From: David Margolis-Pineo
To: Barbara Barhydt; Jean Fraser
CC: DEVELOPMENT REVIEW GROUP
Date: 2/11/2016 1:57 PM
Subject: Review comments for 1363 Washington ave. - Taco Bell

Memo To: Jean Fraser
Barbara Barhydt
From: David Margolis-Pineo
Re: Development Review Comments for 1363 Washington Ave – Taco Bell

Not Approved for Construction
Drawing Title
Layout & Materials

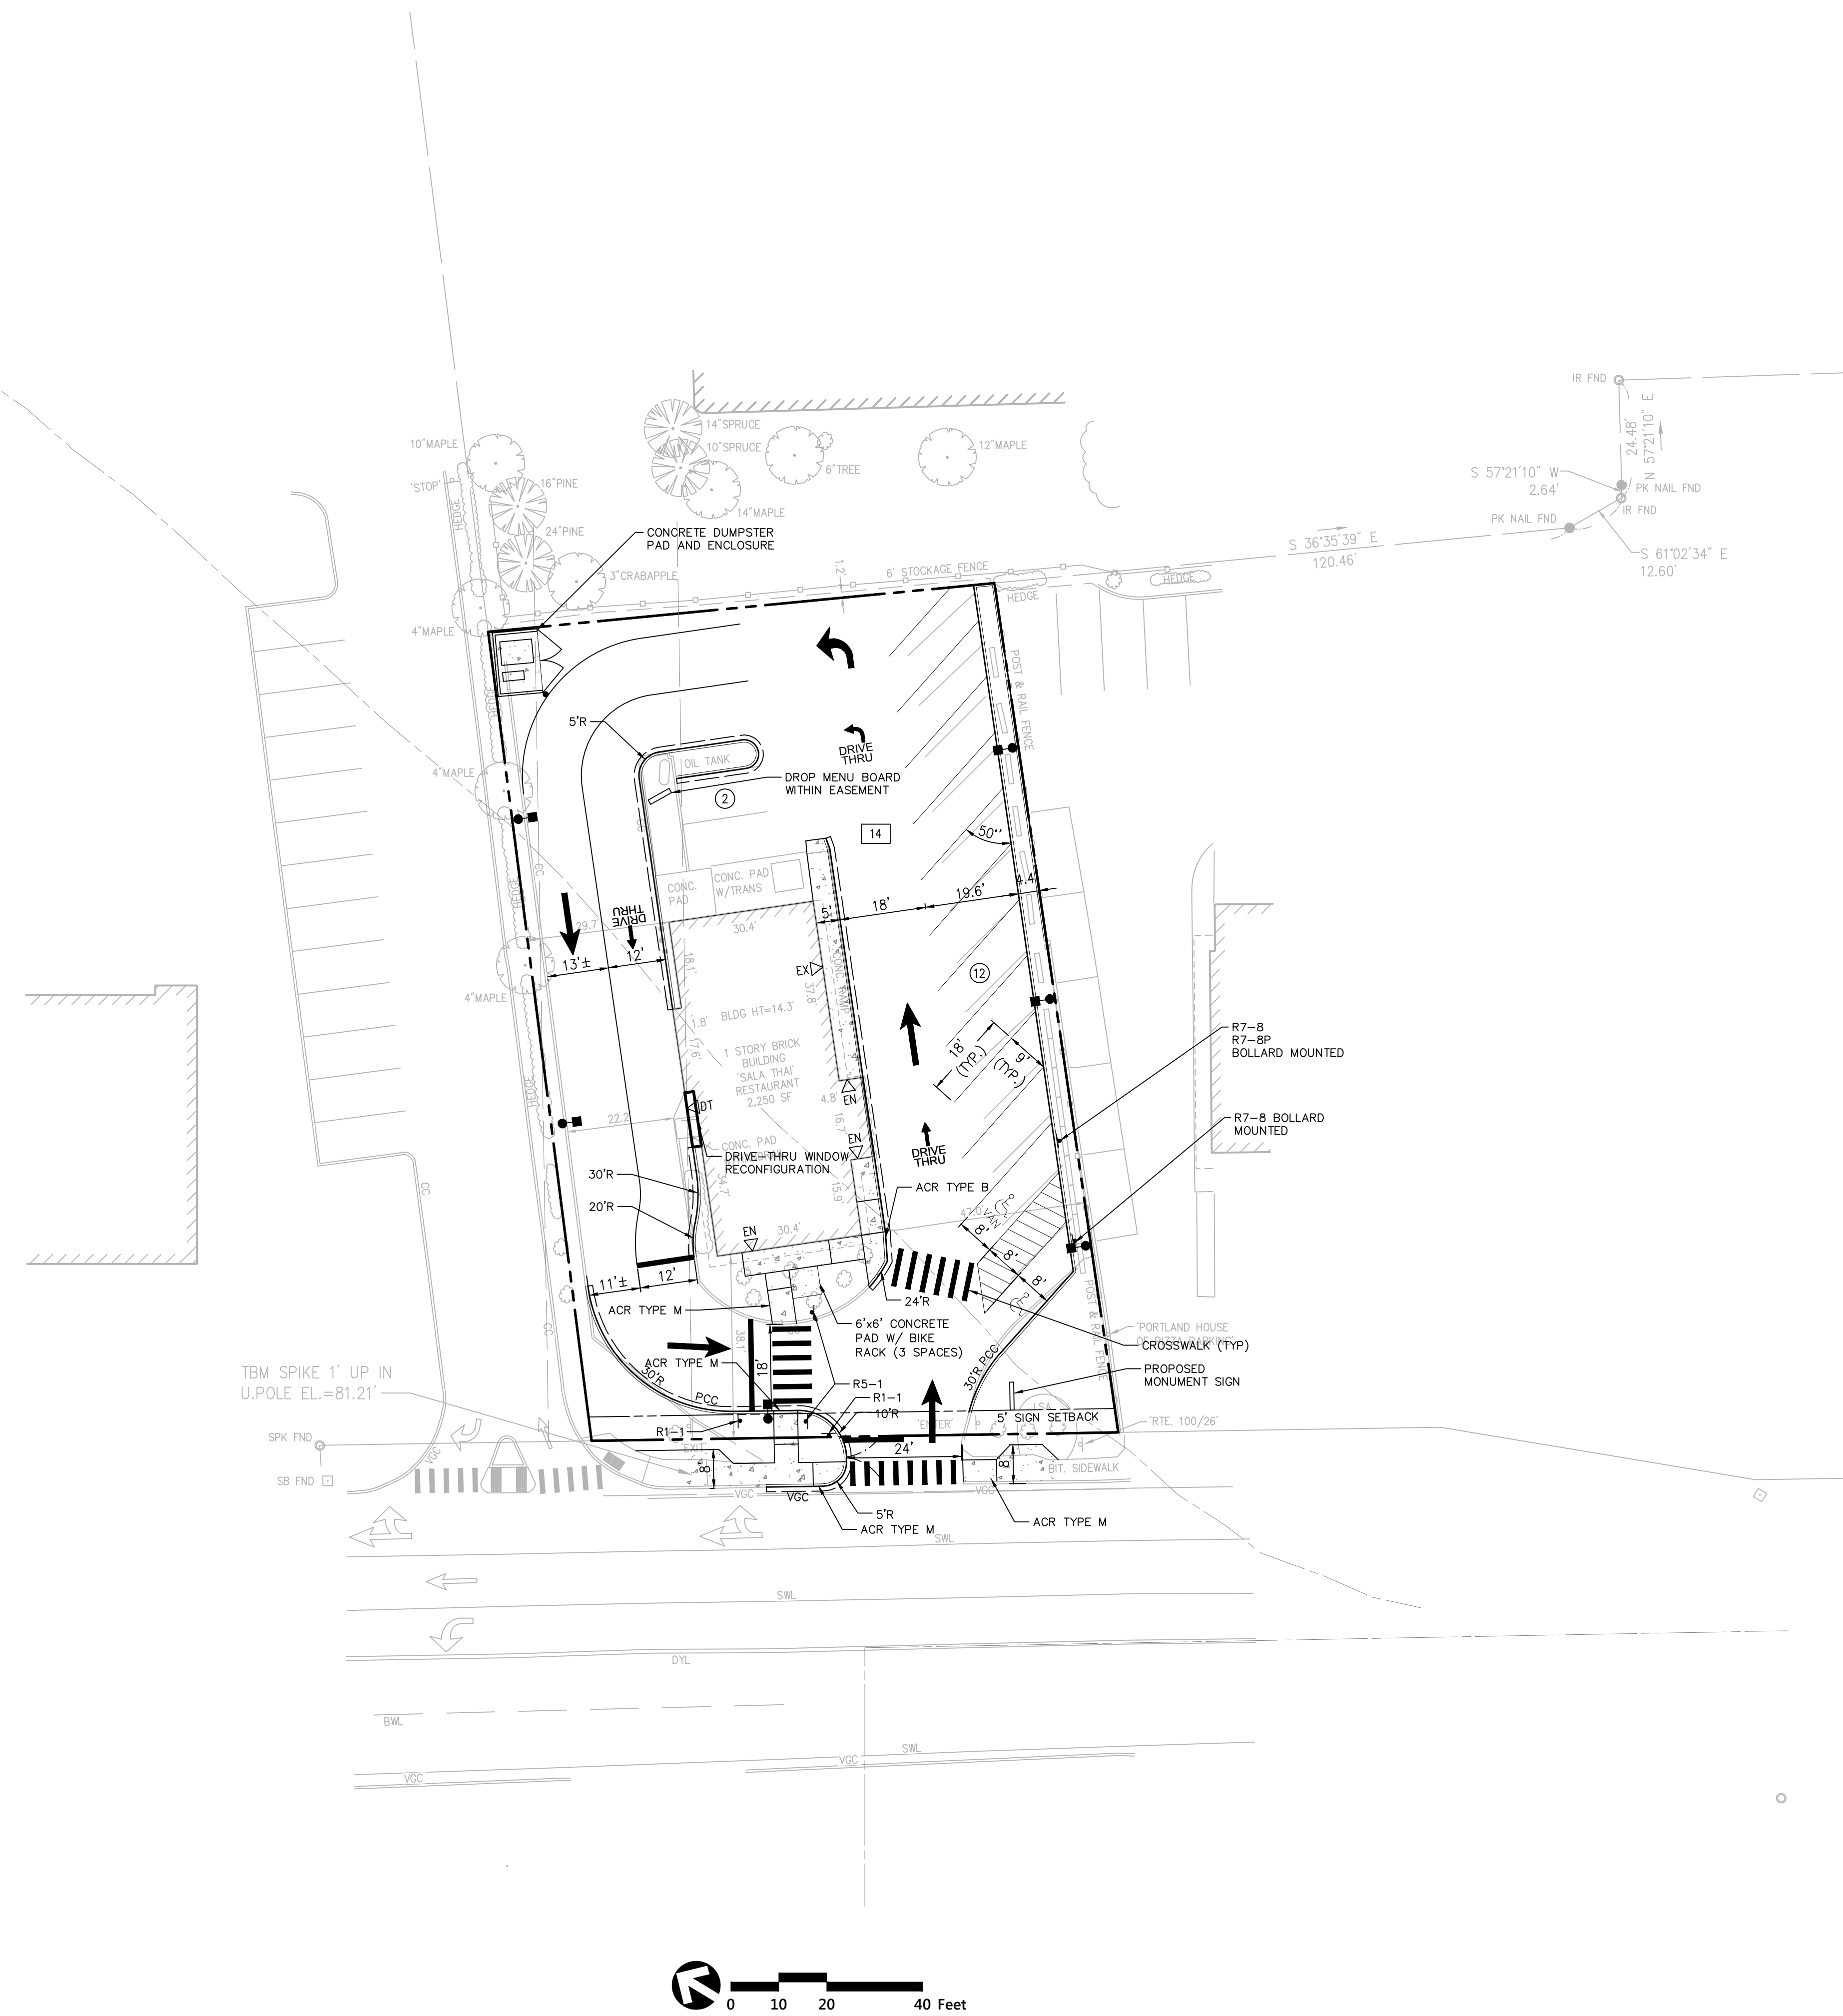
3. Computations for the Wastewater Capacity Application need to be revised.
4. The Washington Ave right of way is approximately three feet from the back of sidewalk. Please bump the sidewalk to the road right of way at the two utility pole locations to make the sidewalk ADA compliant. Thank you.

Not Approved for Construction
Drawing Title
Utility Plan
Drawing Number

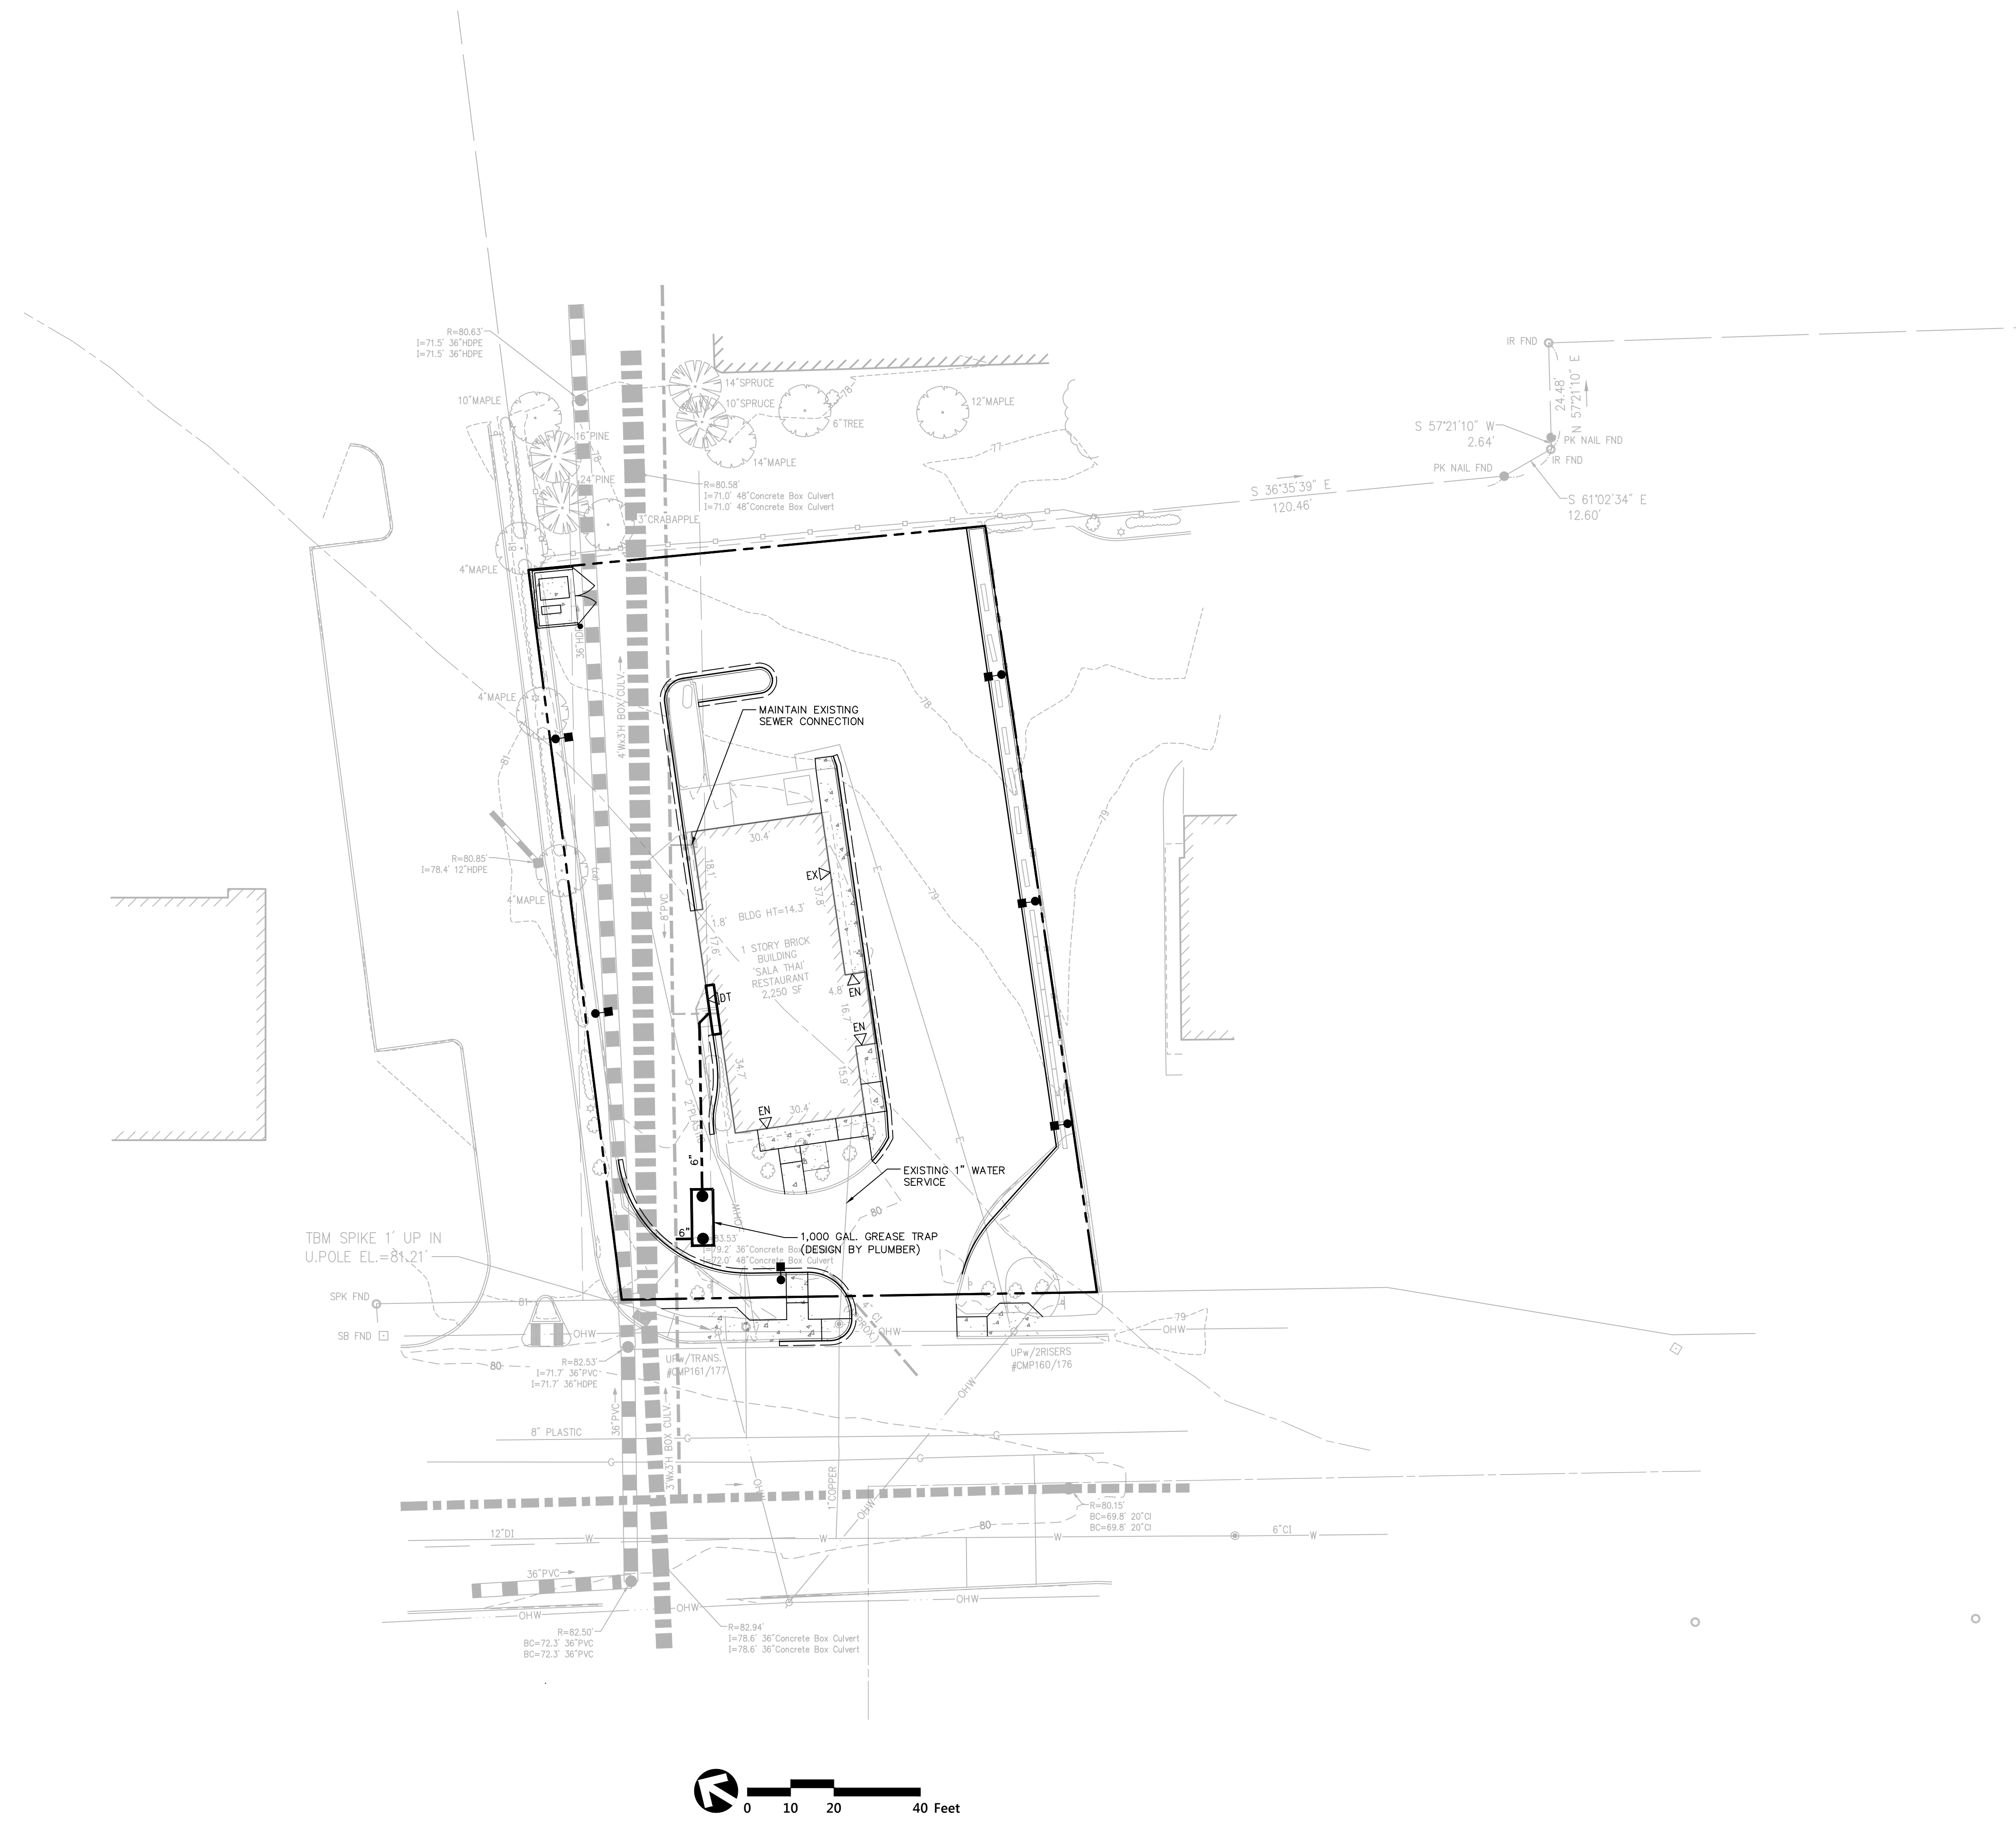
2. It is recommended that the grease interceptor piping be 6" which will allow a Tee/Wye connection to the adjacent 8" sanitary sewer. Elevations will need to be confirmed. Sizing of the grease interceptor shall be reviewed and approved by Rachel Smith (207-874-8833) of this office. Be aware the minimum size of this interceptor will be 1,000 gallons but may be larger based on flow projections.

**BICYCLE RACK SPECIFICATION - BIKE HITCH**  
 N.T.S. Source: VHB LD\_533a

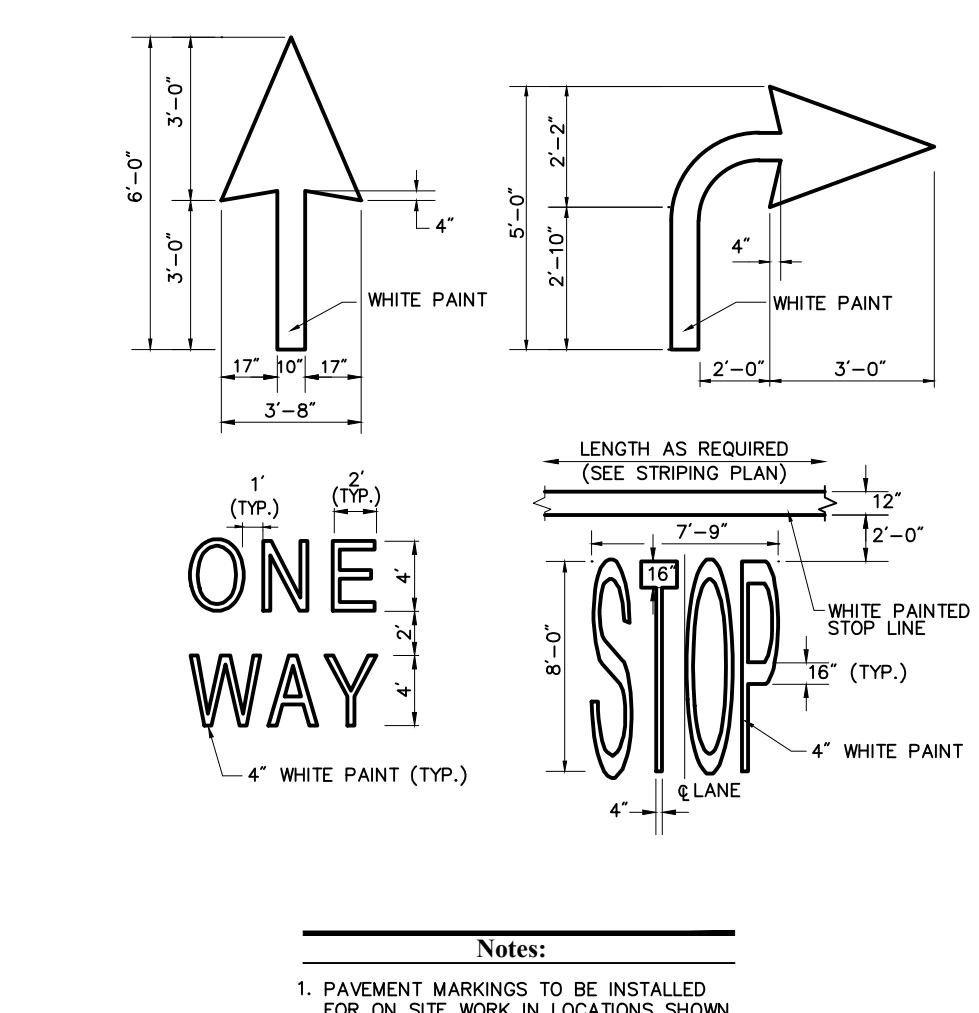
5. The proposed project will require the addition of bike racks. Please supply required number.
